Householder Proforma

Application Ref: 2021/1585

Address: Lower Judd Field Farm, Judd Field Lane, Cubley, S36 9FF

Site Plan - Proposed

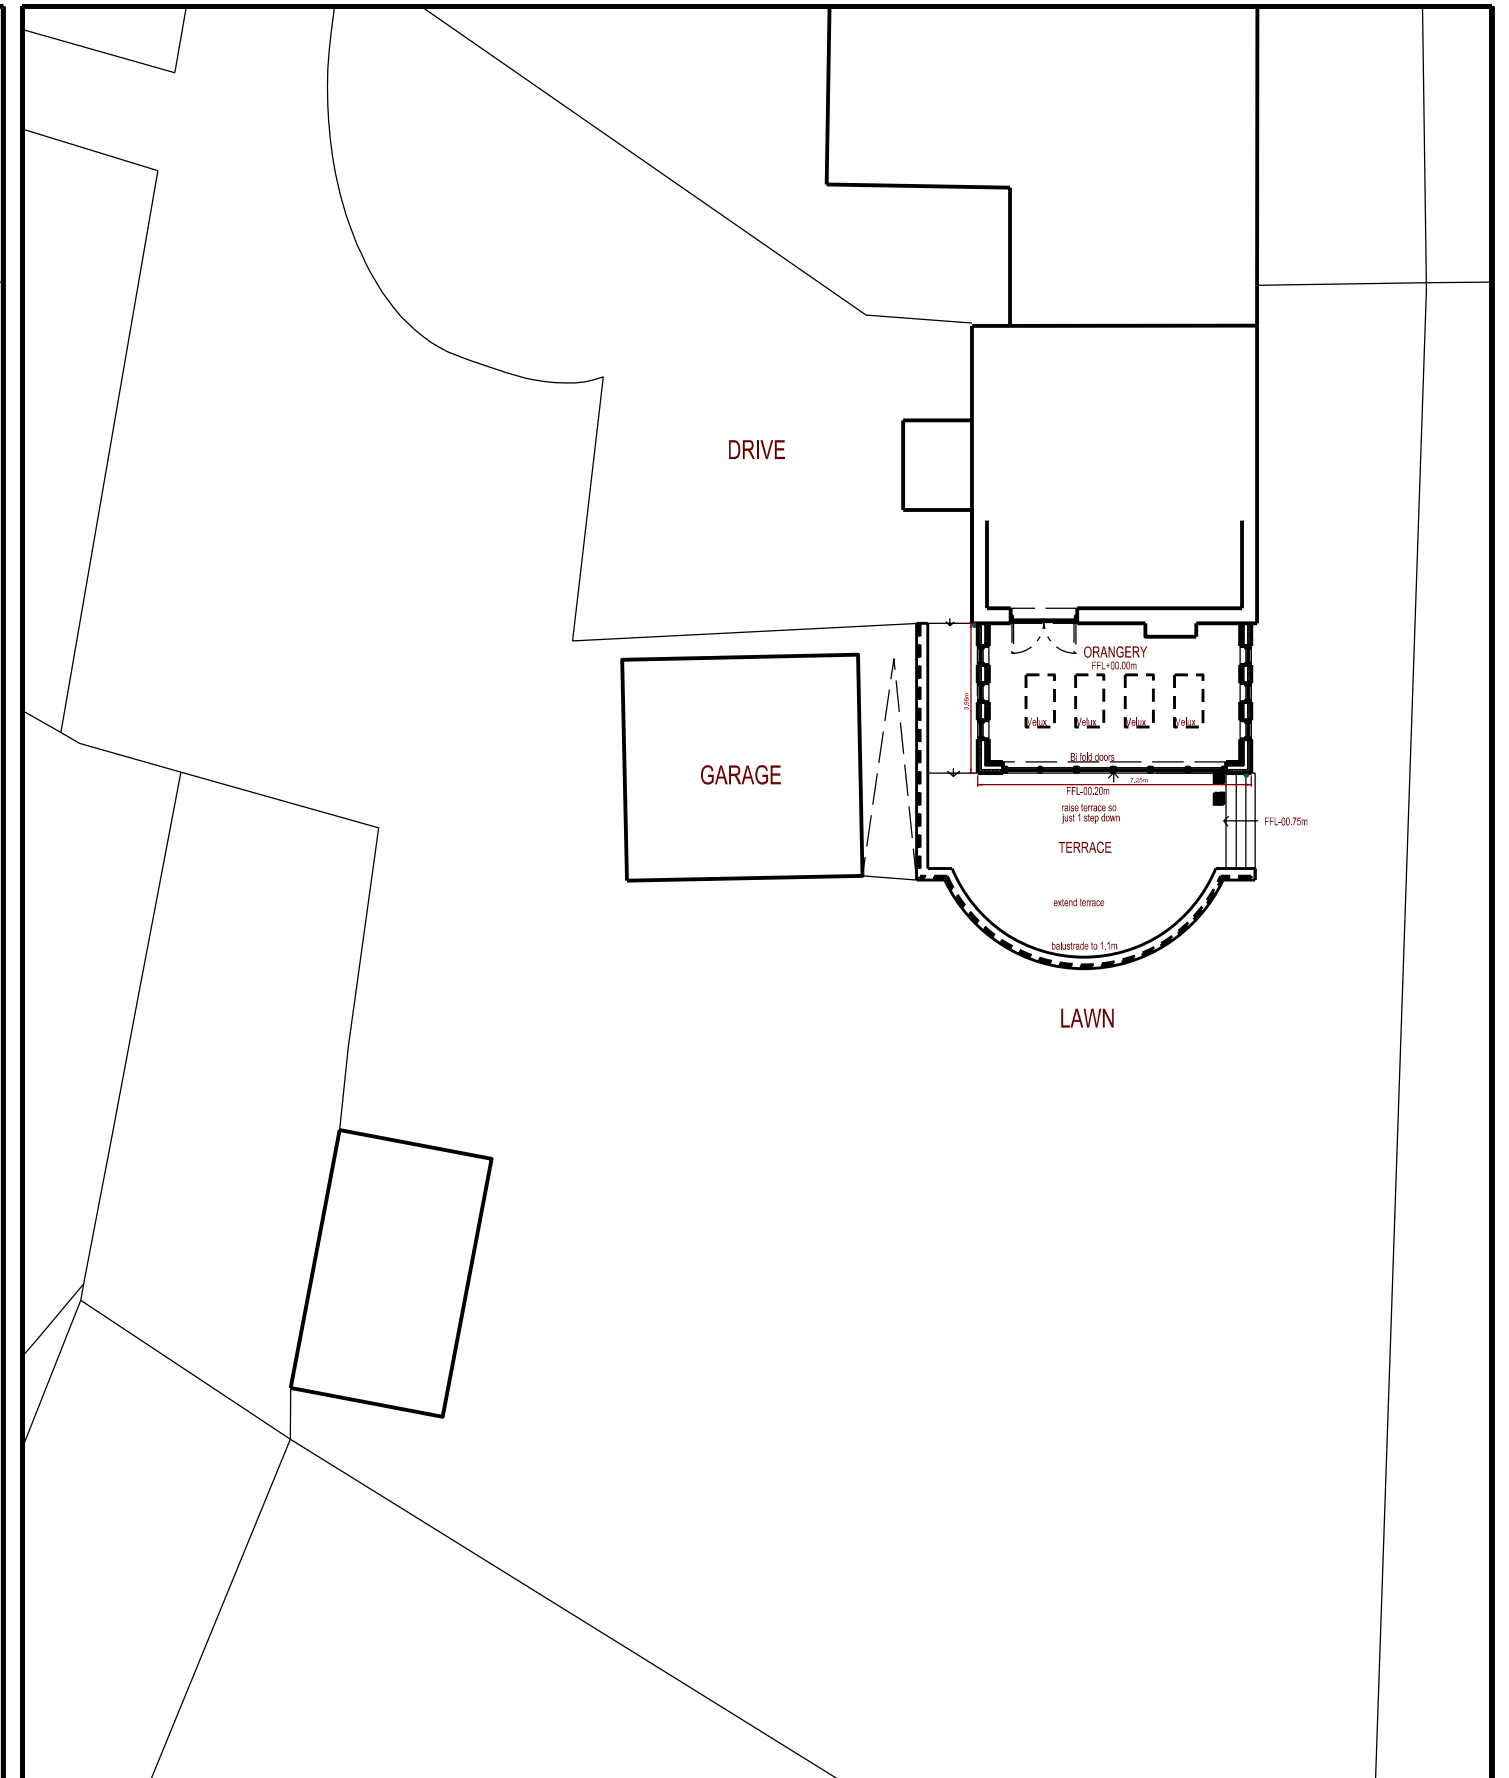
The raised terrace will project into the side garden by approximately 5.15m In a semi-circle shape, will be raised at a height of 1.76m at the highest point and will have balustrade at 1.1m high. The terrace will be built in matching coursed stone.

Drawing Title: Plan & Elevations - Proposed

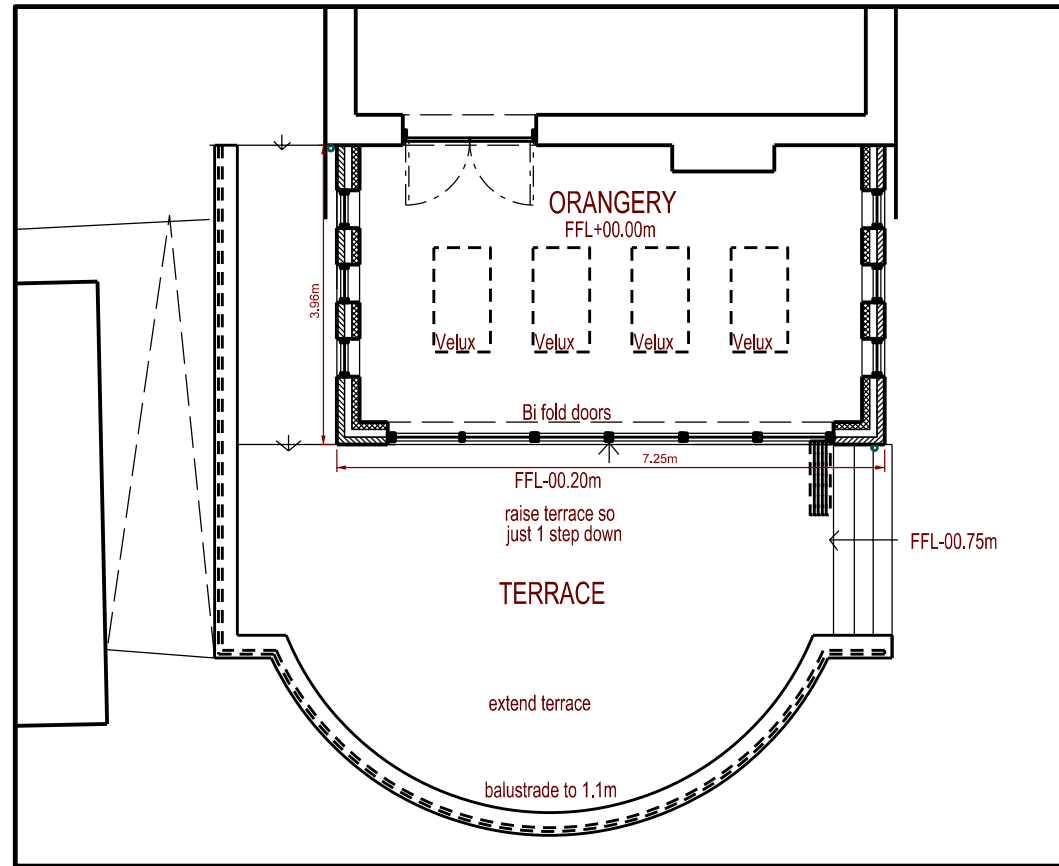
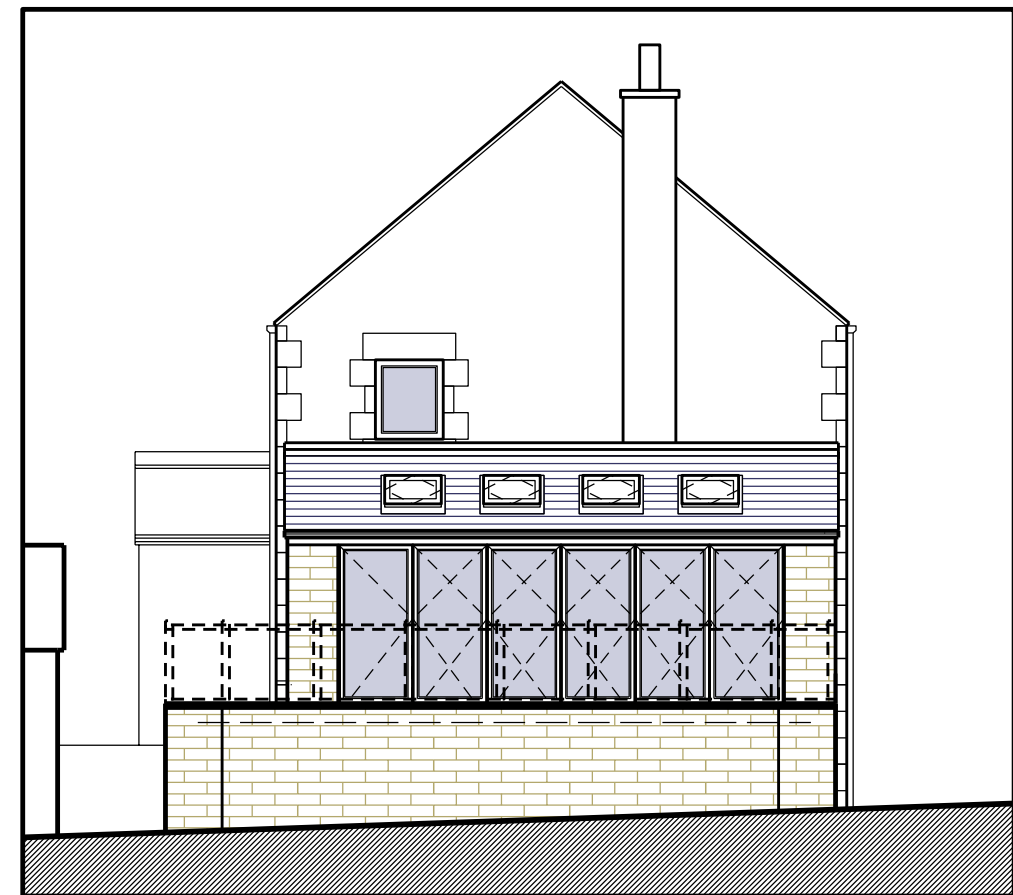
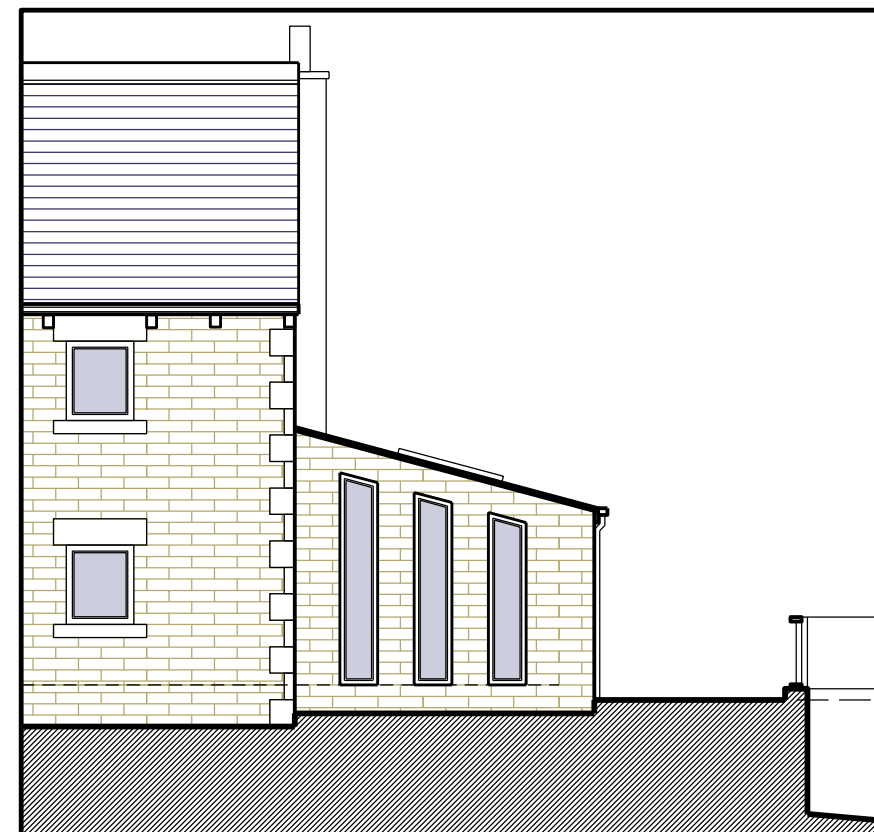
The proposal is for the erection of a single storey side extension to the south elevation replacing the existing conservatory. The proposal will be on the same footprint 3.96m x 7.25m, 2.4m to the eaves and 3.79m total height. The proposal will provide an orangery style extension with 3 long narrow windows on each side elevation and bi folding doors with 6 panels leading to the proposed raised terrace. 4 Velux windows will provide additional light into the room. The materials will be coursed stone and natural blue grey slate with permanent easyslate low pitch system, the windows and doors will be grey PVCu and aluminium. The materials will match those found in the existing property.

The proposed extension will replace the existing conservatory within the same footprint and will therefore not exceed the 100% Green Belt limit. The proposals are in matching materials and the design is more sympathetic to the main dwelling and style than the existing conservatory by way of a lean-to more traditional design. The proposed glazing is not entirely in keeping with this converted barn, but will compliment the old and new design of the property, of which a large expanse of glazing is already existing. The proposals are in line with Planning Policy and in principle acceptable.

Side Extension:	Yes
Single Storey	
1. set back	0.25m from both the front and rear elevation
Two Storey / First Floor	
2. set back / set down (500mm minimum)	
3. less than 2/3 the width of the original dwelling	
All	
4. roof design corresponds to existing	Yes, lean to and matching materials
5. windows / doors of a similar design / proportion	No, the front and rear windows are long and narrow, the side glazed wall (bi fold doors) although not similar in design and proportion, will replace an

existing highly glazed conservatory. In this instance the proposed glazing is acceptable.
6. habitable room windows on the side elevation	Yes, not overlooking any neighbouring properties
7. materials to match	Yes in coursed stone and blue grey slate
8. neighbouring property extended to side or windows?	N/A will not be visible from the neighbouring property.
9. Any change to parking or access?	No
